Your ref: 24.0612  
Our ref: D3.24.0612  
Date: 20<sup>th</sup> December 2024

**App no: 24.0612**

**Address: Land opposite Turner Fold, Read**

**Proposal: Proposed change of use and conversion of single-storey garage/workshop to two storey, two-bedroom holiday let including new dual pitch roof**

1 Ground Level
1 : 50

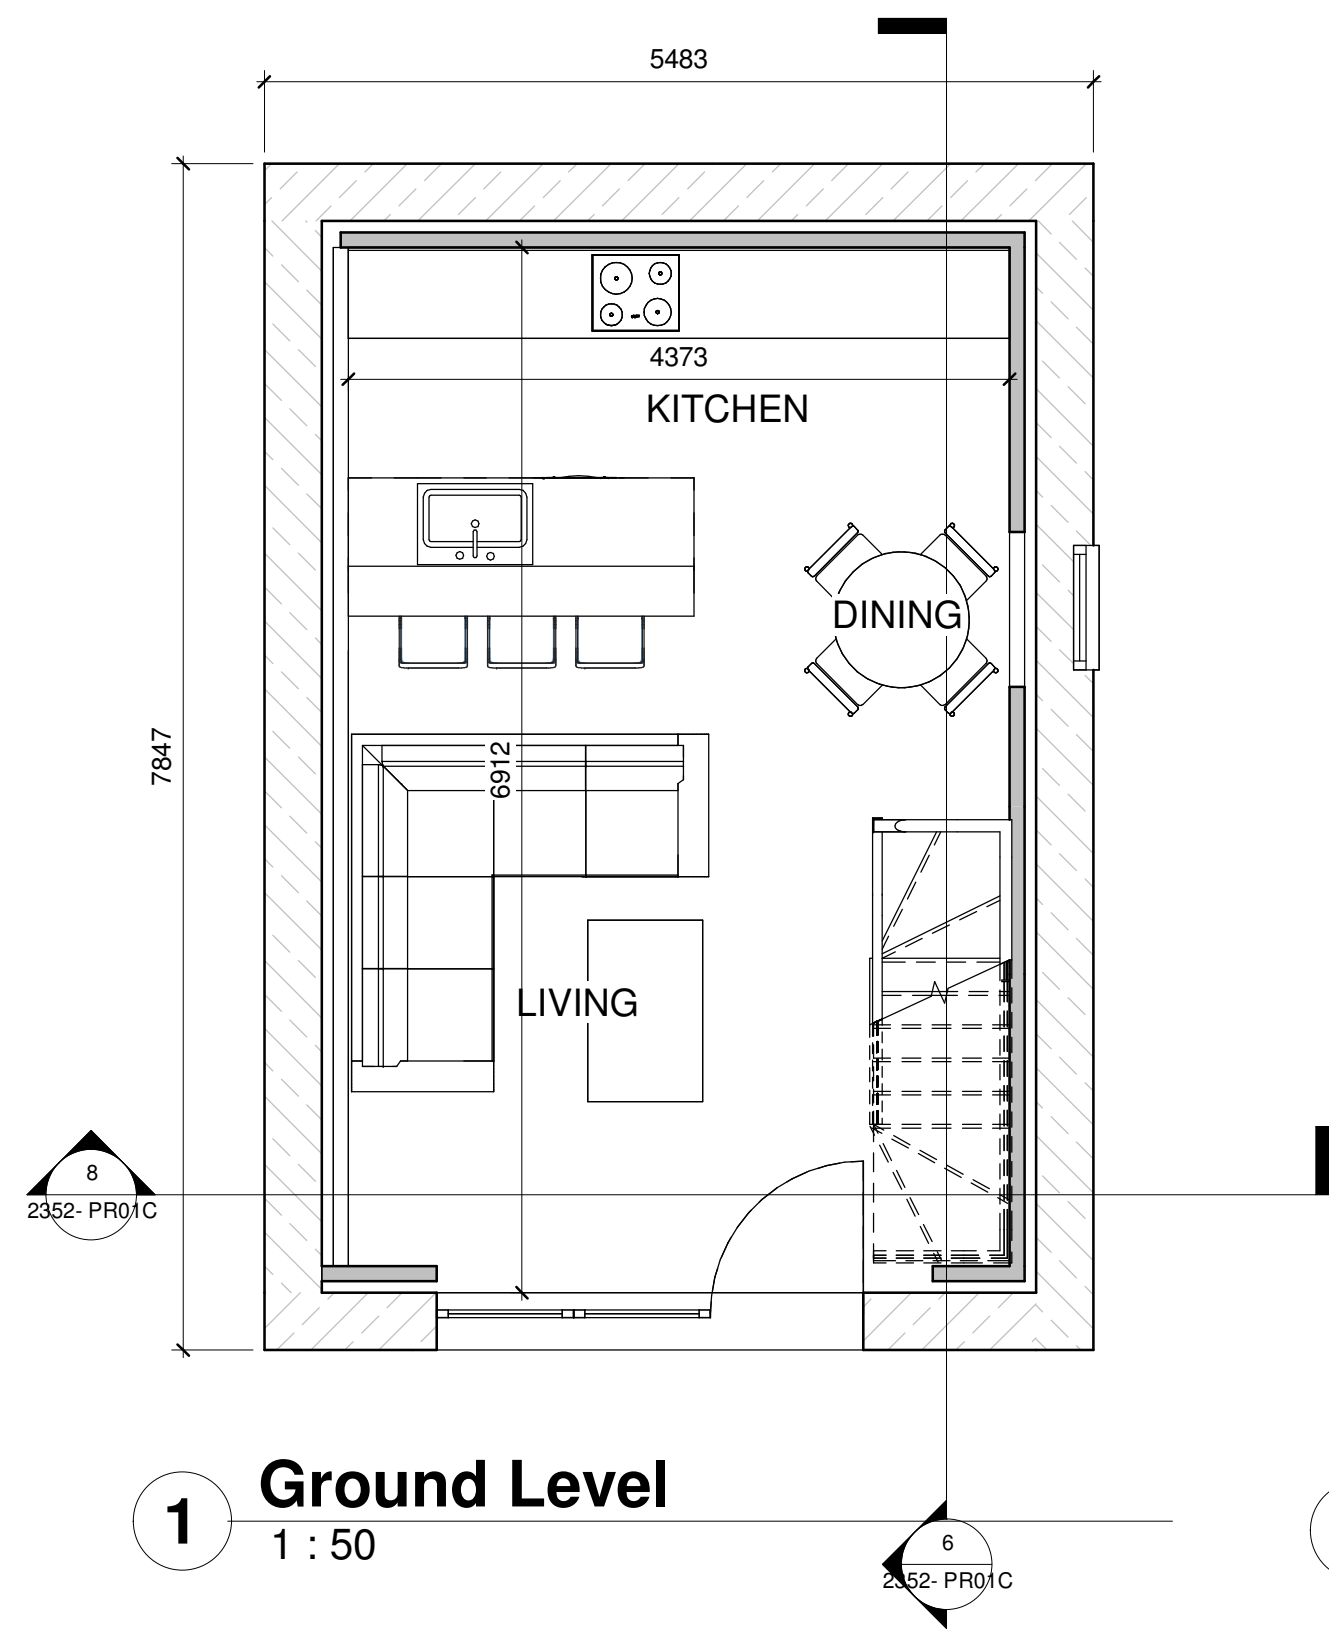
There are no changes proposed to the access itself however the internal area will be increased in size to accommodate 4 car parking spaces.

The applicant has confirmed that two spaces will be for the holiday let and two for the applicant's use, who resides at The Barn, Turner Fold.

The applicant confirms that the off-street parking shown at no.3 Turner Fold was an error.

The surface materials of the additional area of hardstanding for parking must be paved in a bound and porous material and surface water drainage needs collecting before it enters Turner Fold.

1. Prior to first use of the development hereby permitted, the car parking shown on the approved plans shall be provided and paved in a bound and porous material. Surface water shall be collected prior to being deposited onto the adjoining highway Turner Fold. Reason: For highway safety.
2. Prior to first use of the development hereby permitted a secure cycle store for 2 bicycles shall be provided and maintained thereafter for that purpose. Reason: To support sustainable travel.
3. The visibility splays shown on the submitted drawing shall be maintained with all vegetation, walls, fences, etc shall be kept below 1m high in perpetuity. Reason: For highway safety.

DRAWING TITLE:  
**VISIBILITY PLAN**

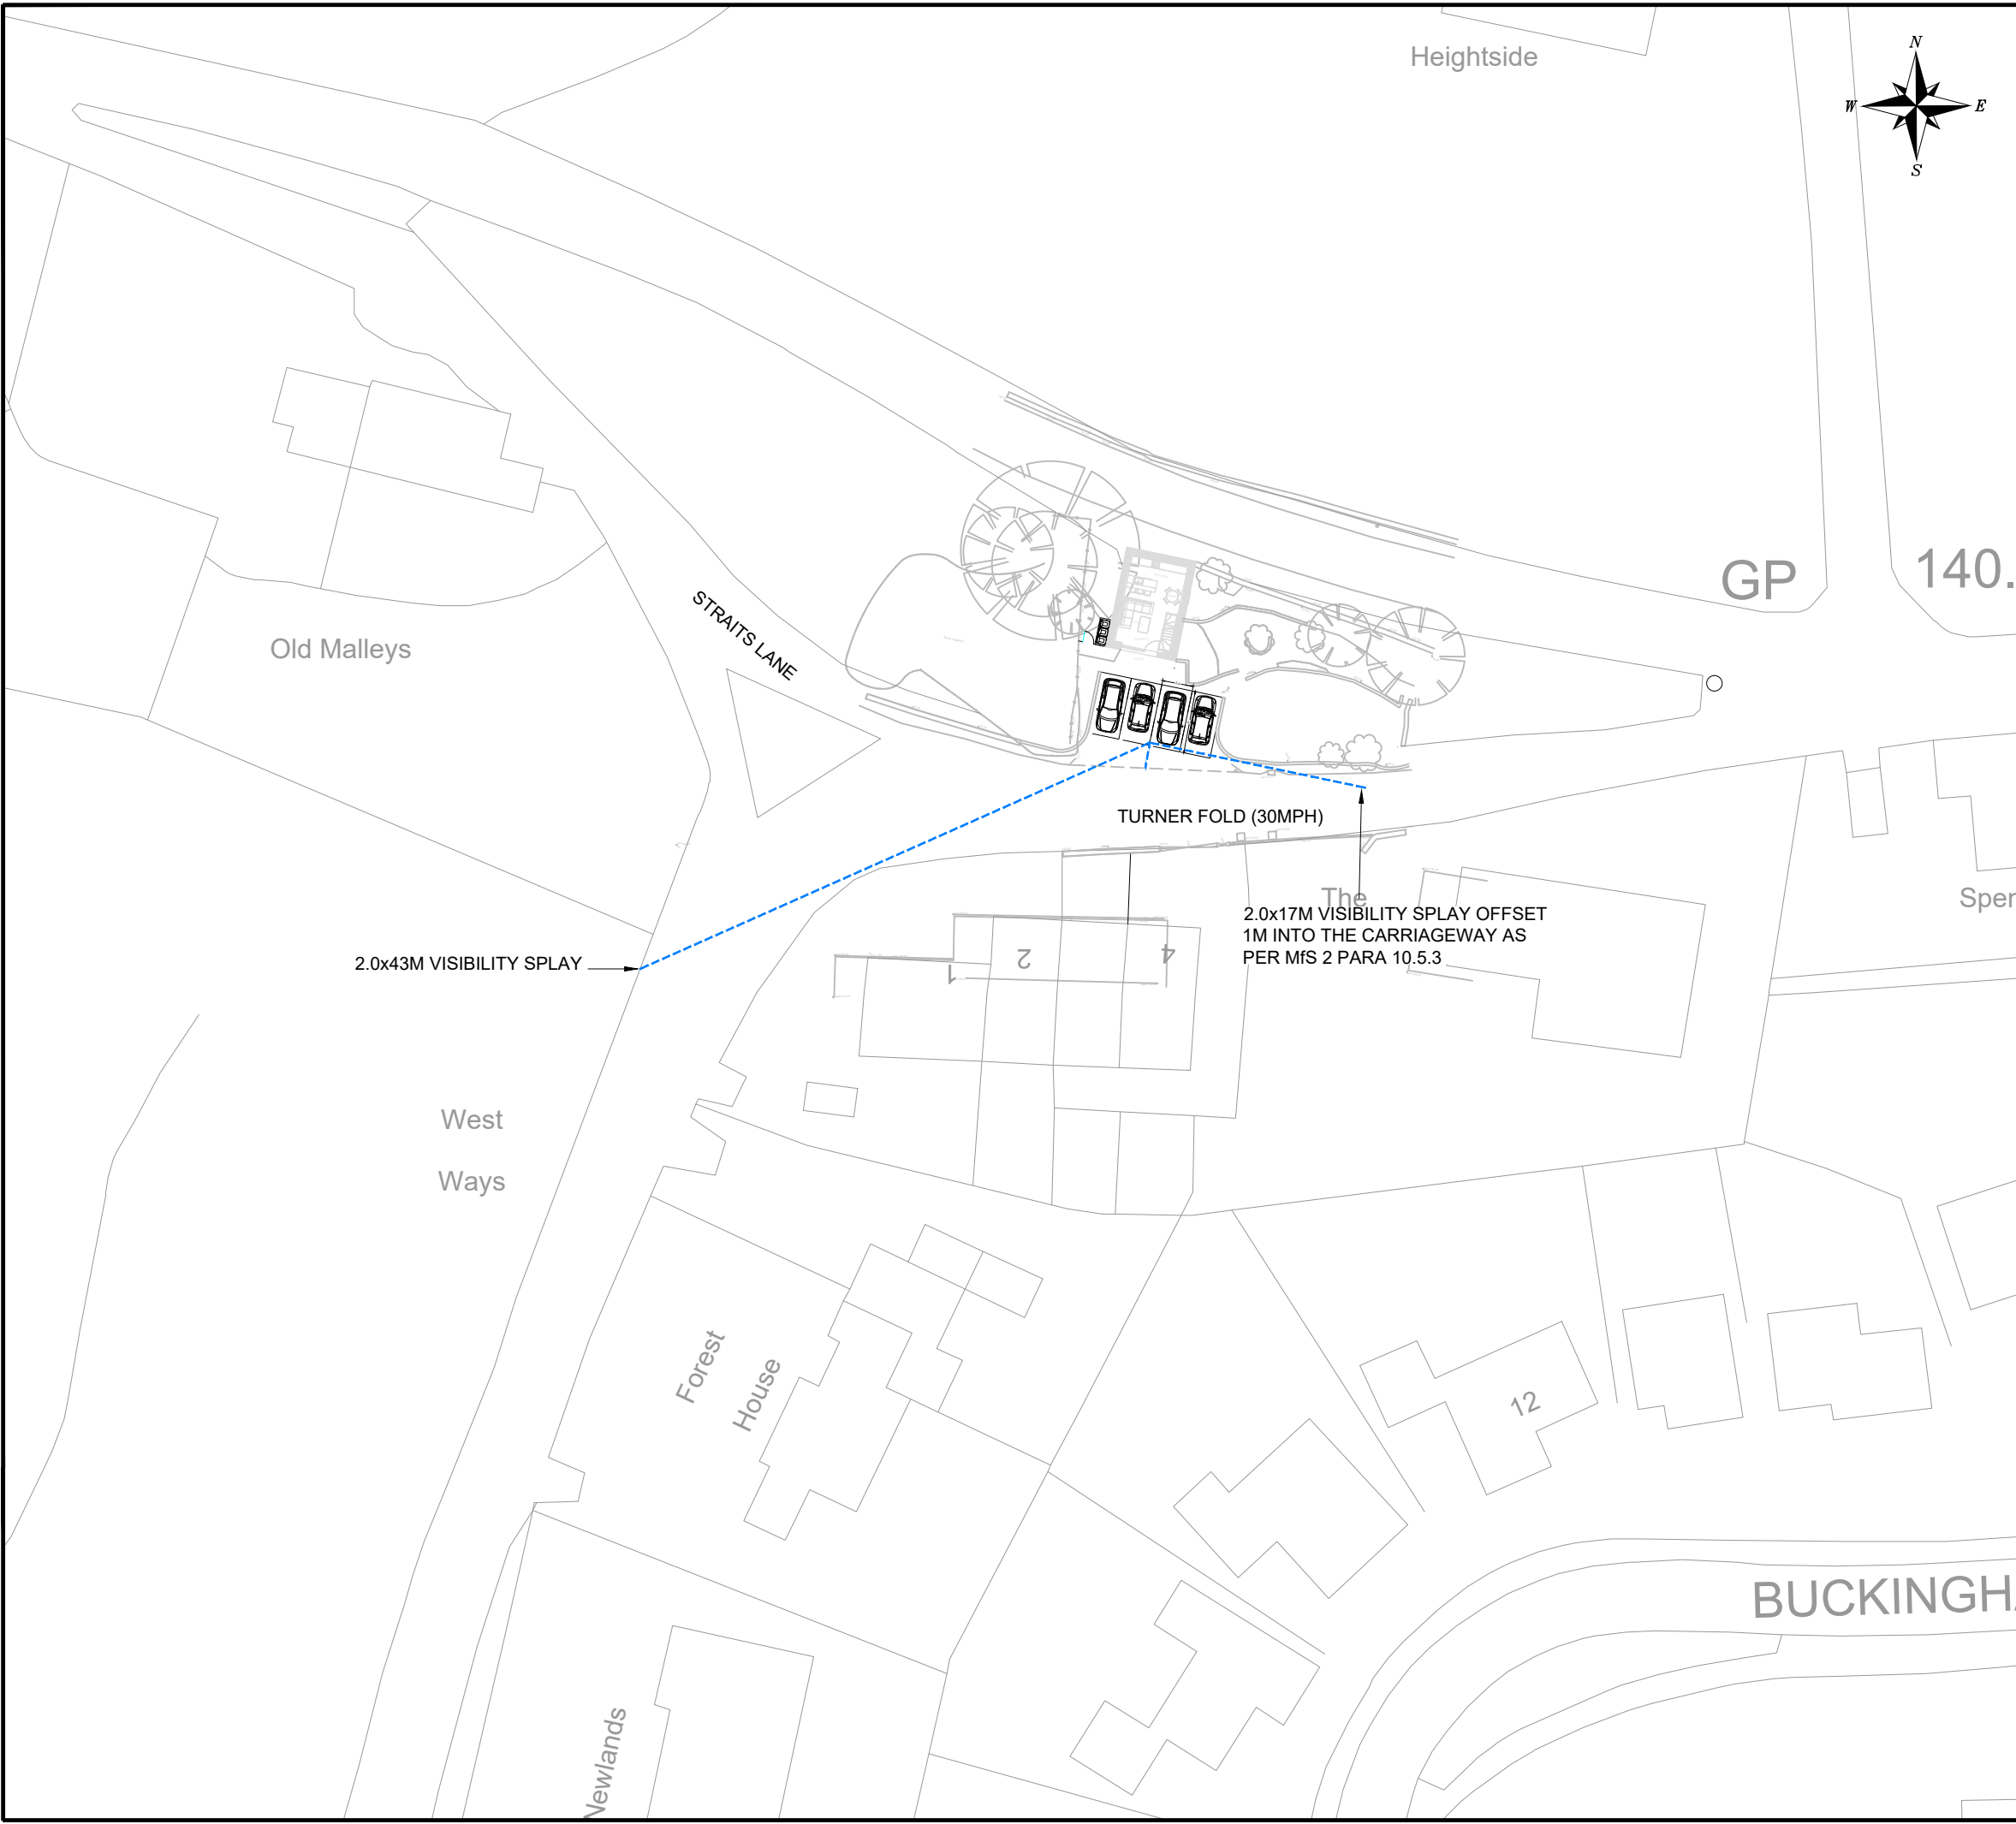
Upon visiting the site, it is evident due to the geometry of Turner Fold and the on-street car parking which occurs that vehicle speeds will be below 30mph. A visibility splay drawing is provided, as requested which shows splays of 2m by 17m to the east side and 2m by 43m. This is considered acceptable.
